MMC Garage: Response to City Questions on Traffic Management Plan

With Travis on vacation this week, I'm stepping in to provide answers to the City's questions on the Traffic Management Plan. Below you will find our responses to outstanding questions. Also attached is a revised Traffic Management Plan with added notes reflecting our responses below as well as copies of the emails with the original questions. Please let me know if you have any other outstanding questions on this work.

Questions from DPW (Mike Tremblay email dated 5/21/19)

Maine Medical Center Parking Garage		St. John Street - Utilities Work Zone Traffic Control Plan		FIGURE 1		
Shaw Brothers Construction, Inc. 341 Mosher Road, P.O. Box 69 Gorham, Maine 04038 (207) 839-2552		DRAWN:	M.E.		DATE:	3/5/19
		DESIGNED:	-		SCALE:	1"=125'
		CHECKED:	-		FILE:	-
		FILE LOC:	-

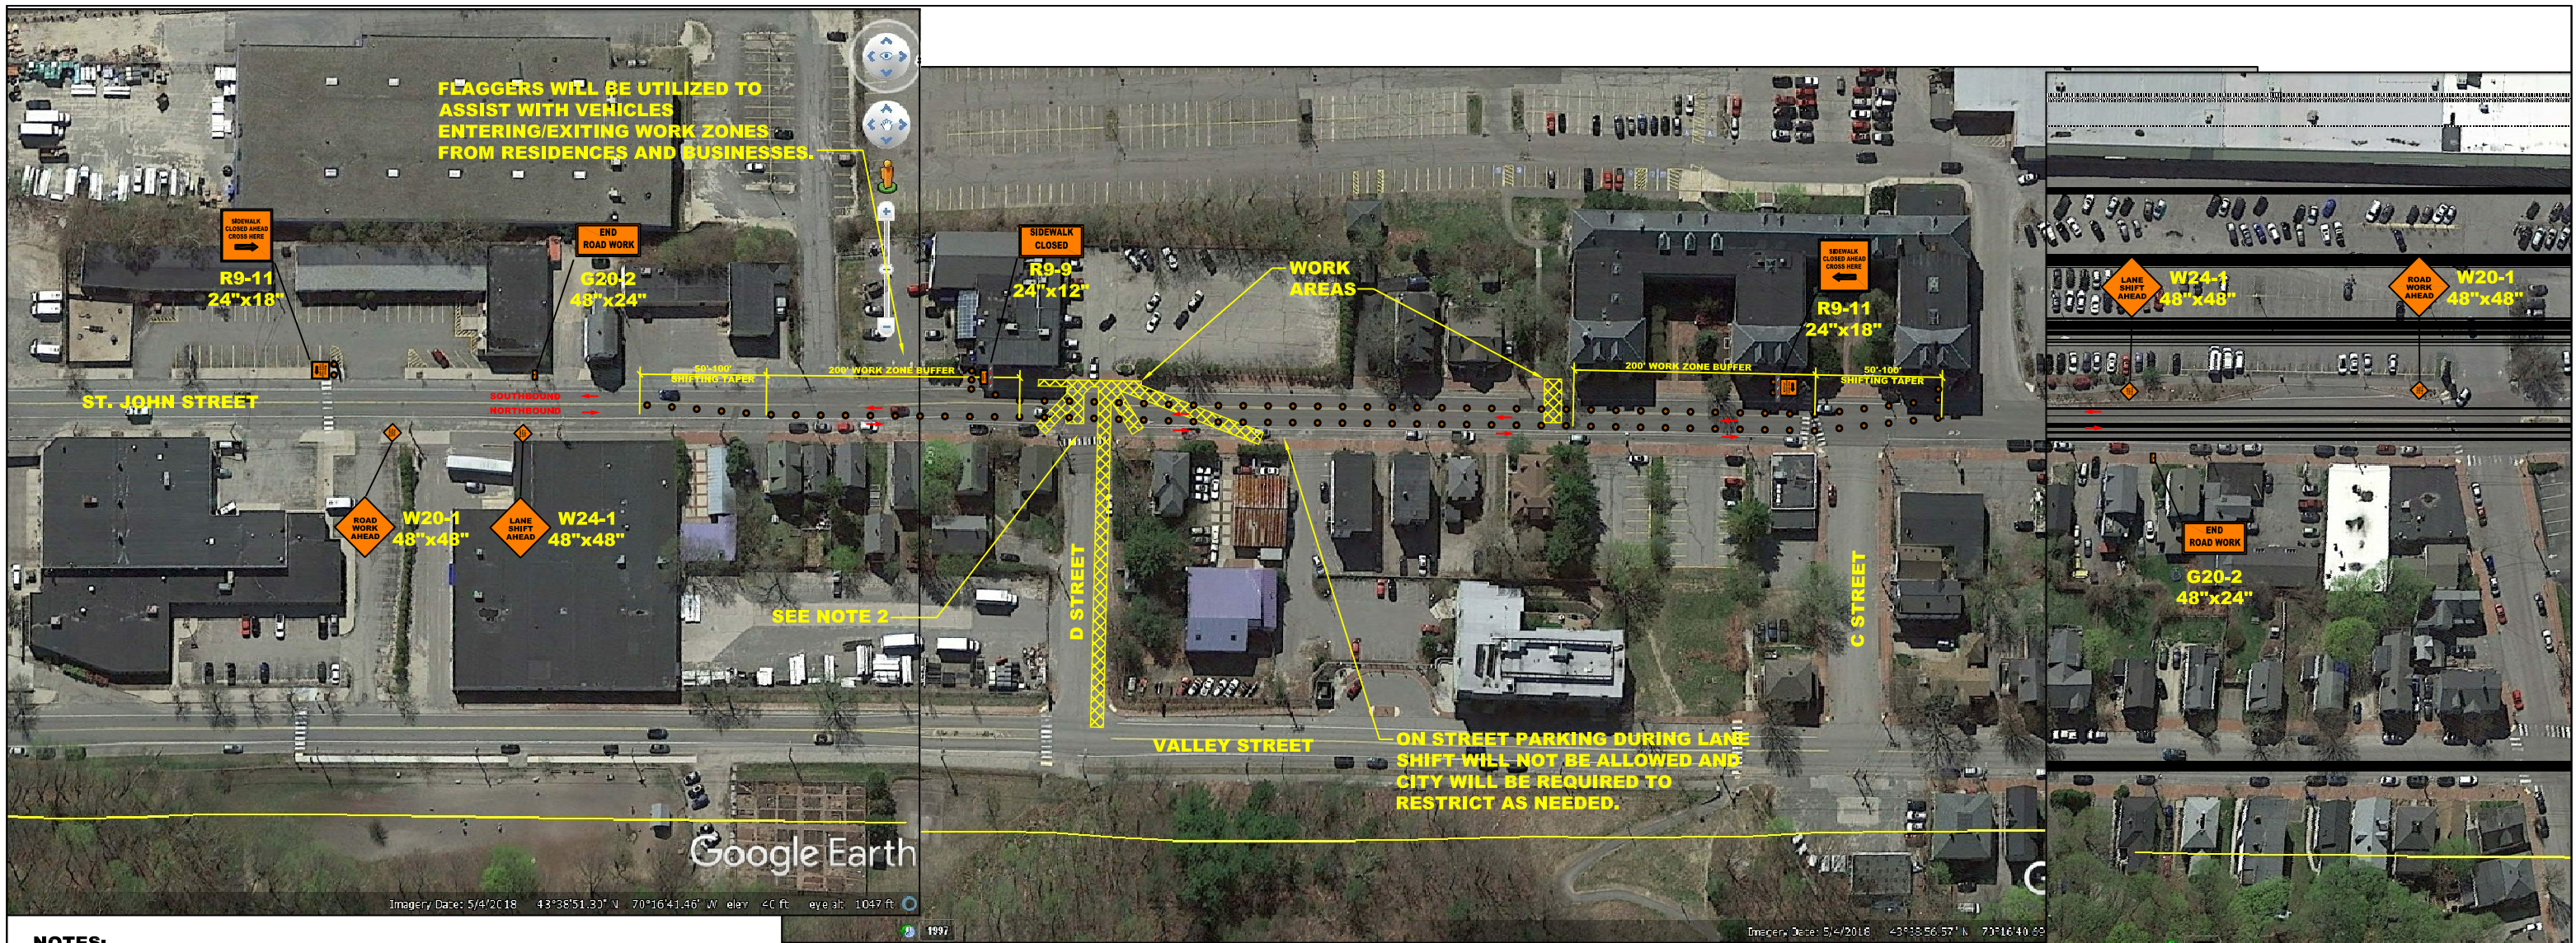
- On-street parking during lane shift is to be coordinated by contractor, not City. Contractor is required to seek out necessary Roadway Occupancy Permits in order to restrict parking, as needed, during the project.

- Confirm crosswalks across D Street will remain open during the duration of work depicted on Sheet 1.

- Confirm that smaller work area on the northern part of the work zone will take the entirety of the phase depicted on Sheet 1. If the work is completed before the work in the St. John Street/D Street intersection, the work zone should be reduced accordingly.

- Shifting tapers should be no less than 75 feet, per MUTCD (10 foot shift, 30mph roadway).

Consigli will purchase parking occupancy permits from the City of Portland on St. John St. Currently, Consigli has a permit for 3 spaces on St. John St. and more will be acquired as necessary while making effort to minimize spaces taken to be left for public use.

The D-Street cross walk will remain open throughout the work and alternative pedestrian access across D-street will be provided when utility work enters the existing cross walk.

The small work zone, just south of 220 St. John St., will be completed with the St. John St. work shown on drawing 1 of the Traffic Management Plan. Work zones will be adjusted to maintain the minimum amount of space needed to complete the construction.

This is noted on the Traffic Management Plan.

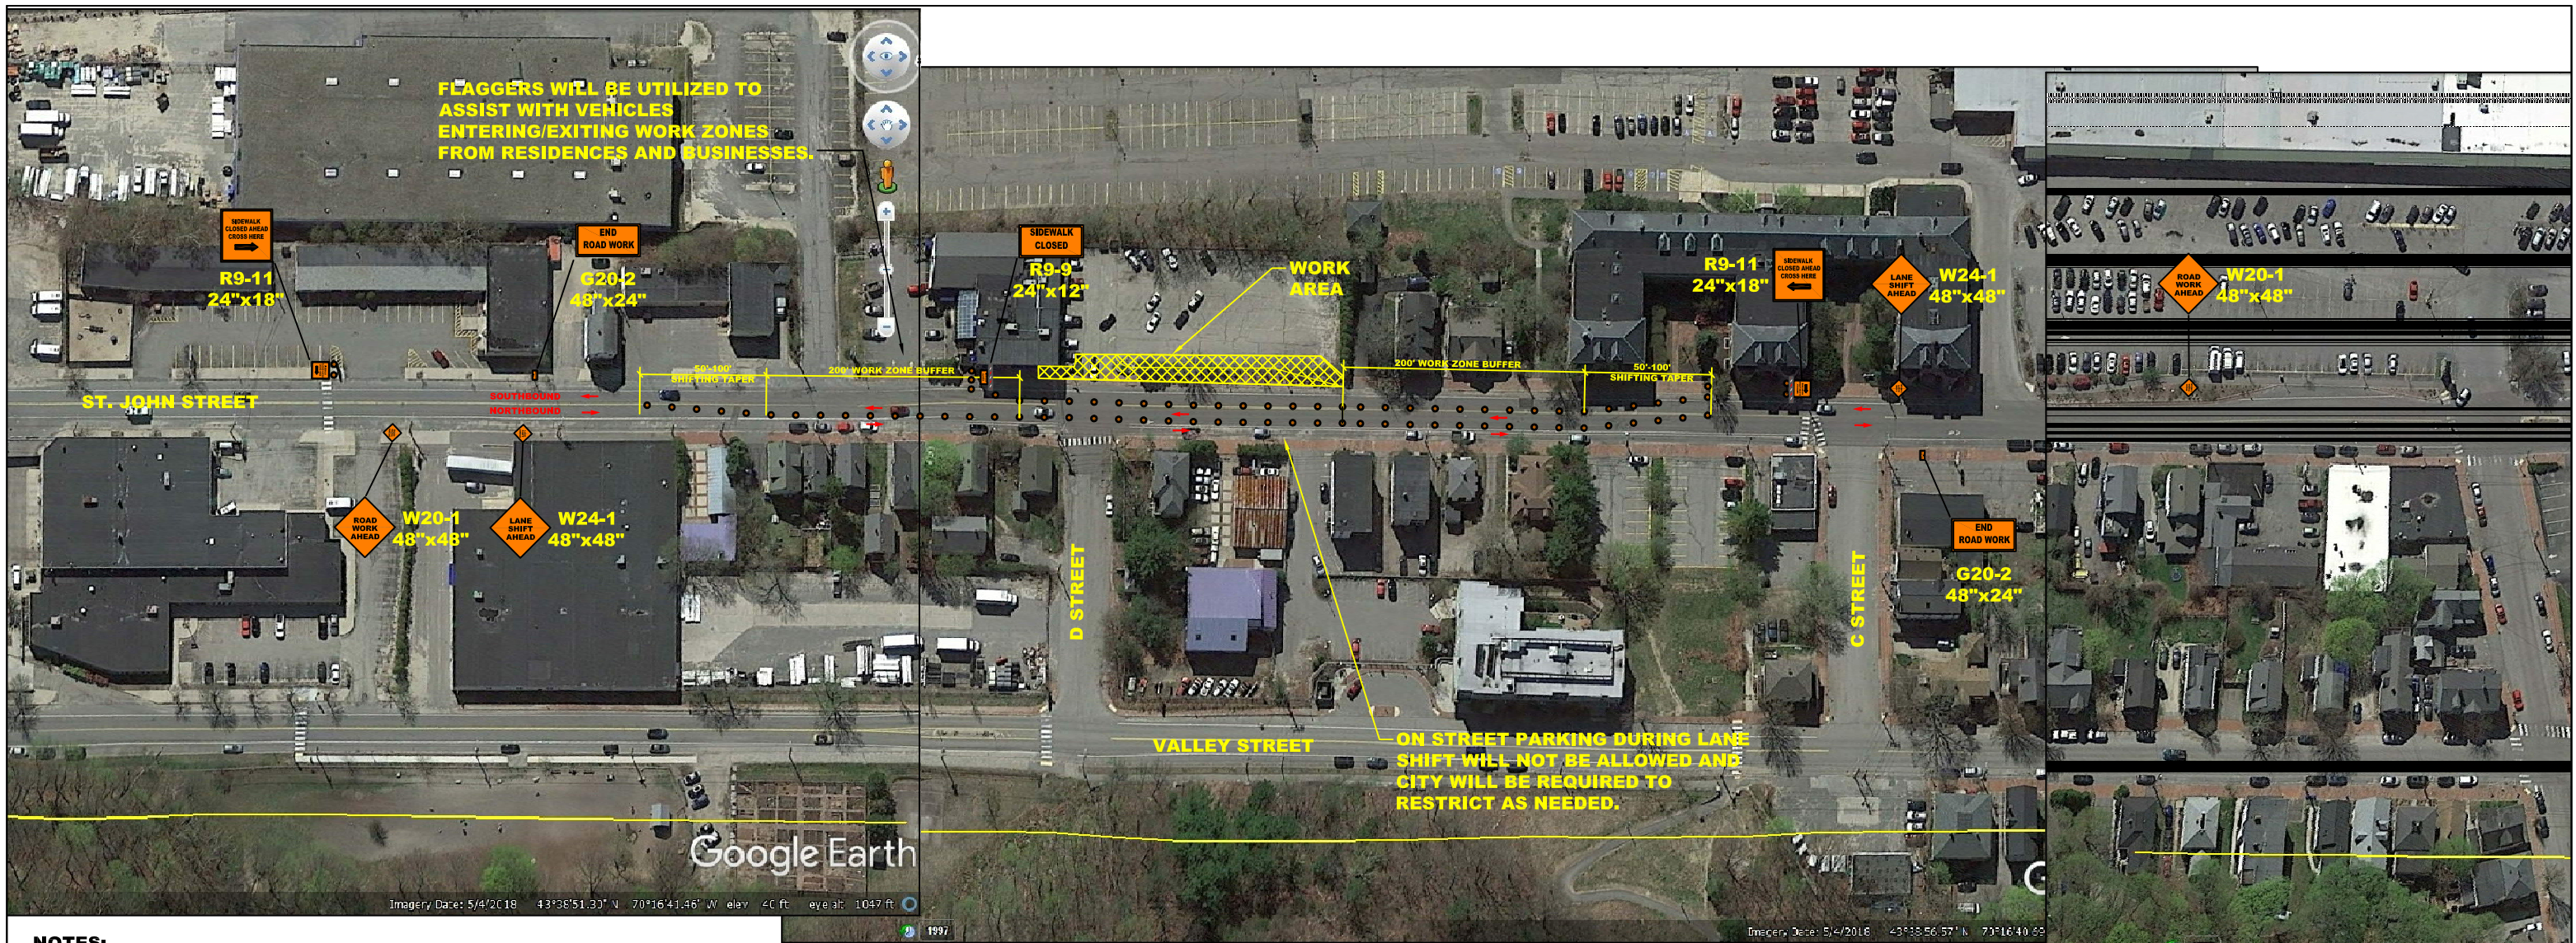
- Same notes as above regarding taper length.

This is noted on the Traffic Management Plan.
